**LOG CABIN & TOURING CARAVAN SITE
IRBY HOUSE
MILLGATE
WHAPLODE
SPALDING
LINCS
PE12 6RT**

PLANNING DESIGN & ACCESS STATEMENT

Reference: PE-00446-16 **Case Officer:** David Grant
Location: Rer Of Irby House Off Little Lane Whaplode Spalding
Proposal: Use of site for holiday log cabins and touring caravans

LOCATION & SITE LAYOUT PLAN.

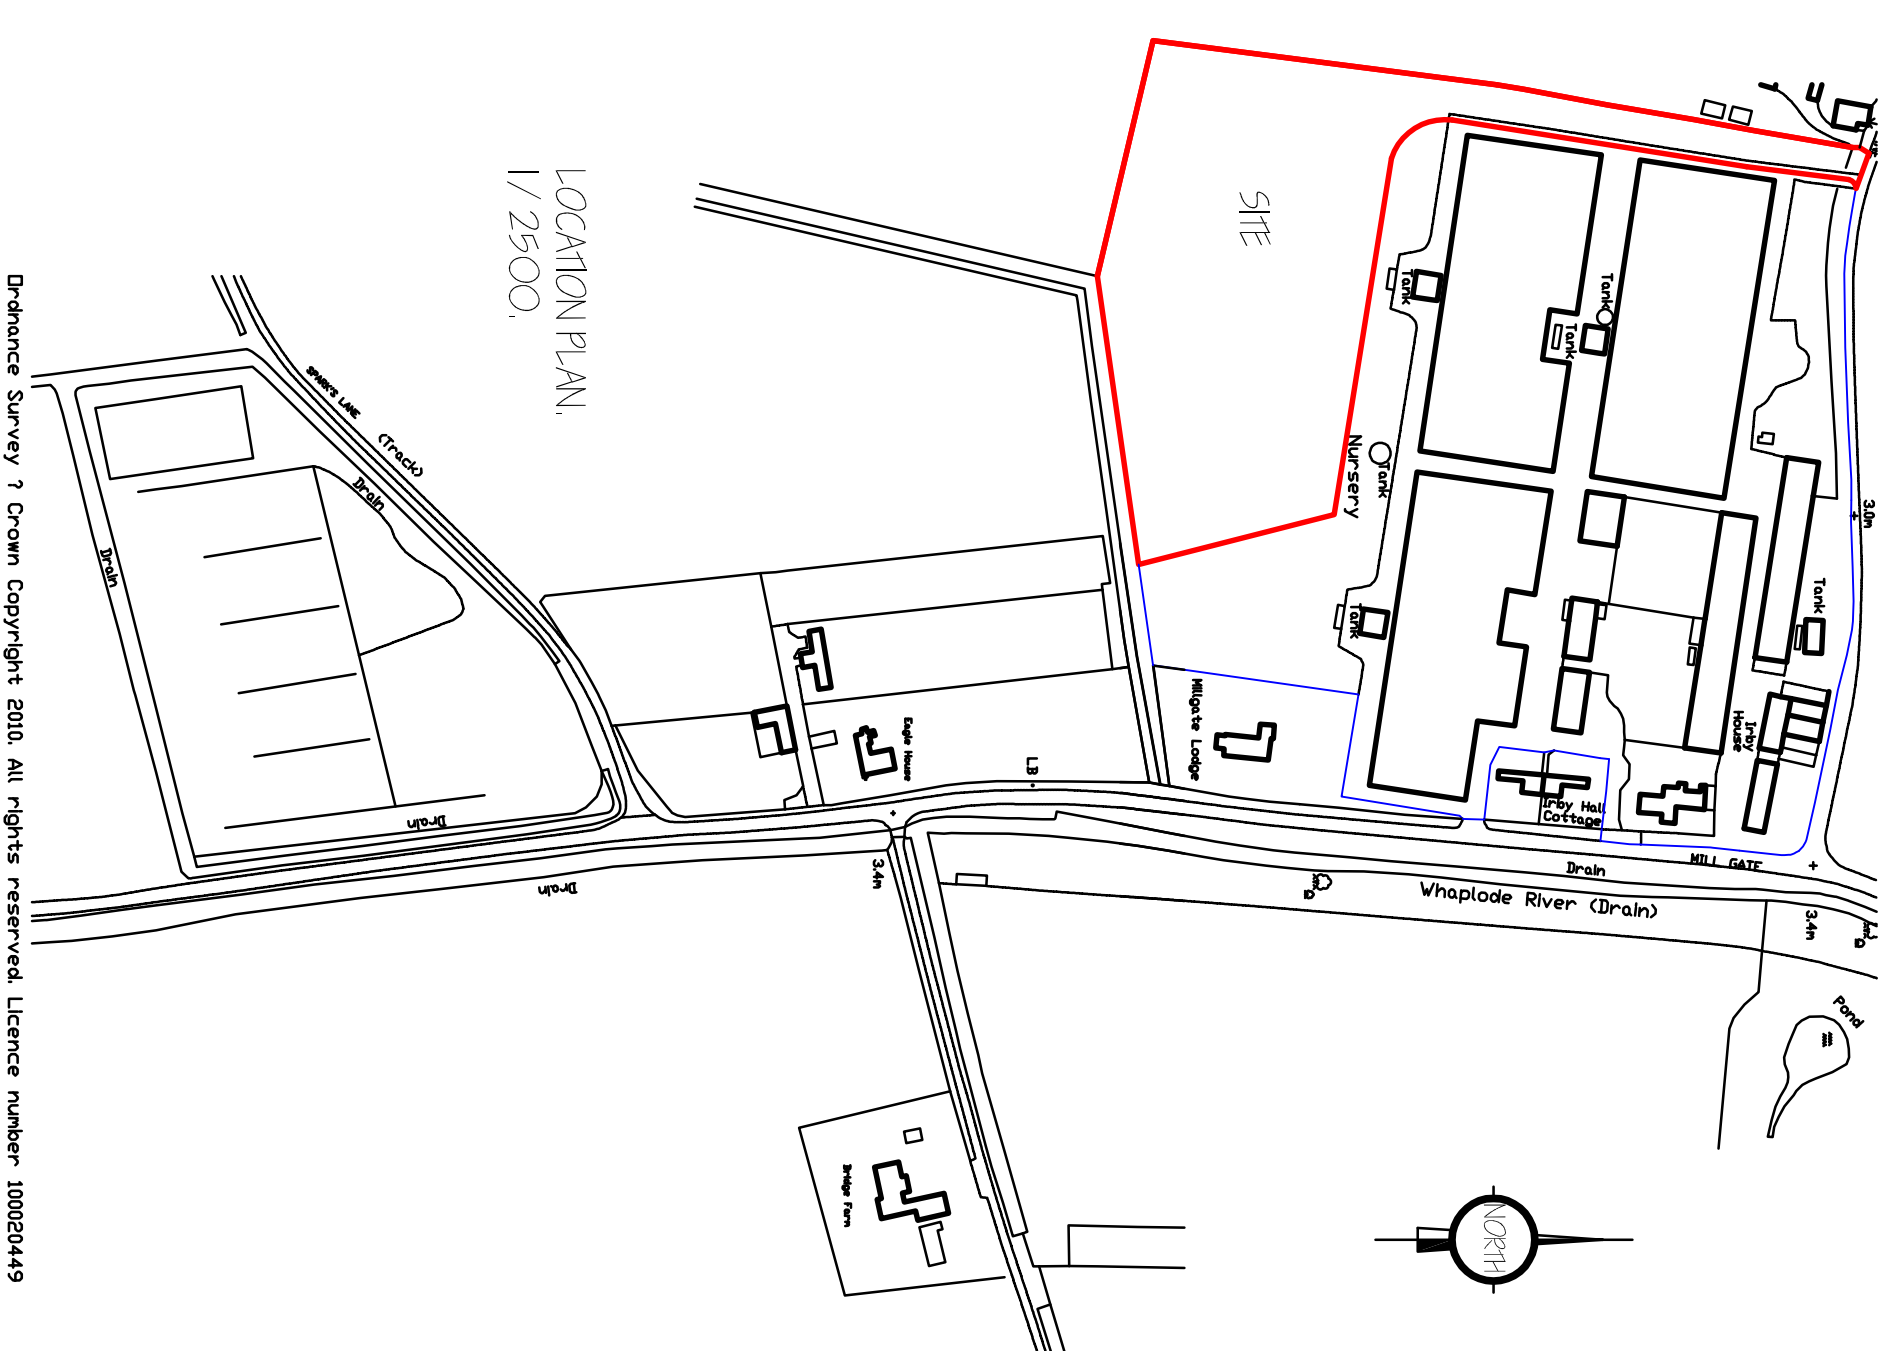
The junction radius on the east side (I don't think there would be any arrivals from the west) would need to be large enough to allow a car towing a caravan and possibly a mobile home delivery lorry to be able to turn in and out without over-running the highway verges Bob.

Little Lane is single track beyond the commercial buildings and we might therefore require a passing place. Whilst your proposal drawing shows only a few touring caravan pitches and so the frequency of visitor's arriving and departing at the same time and meeting on the highway might be low, the lane is used by other vehicles.
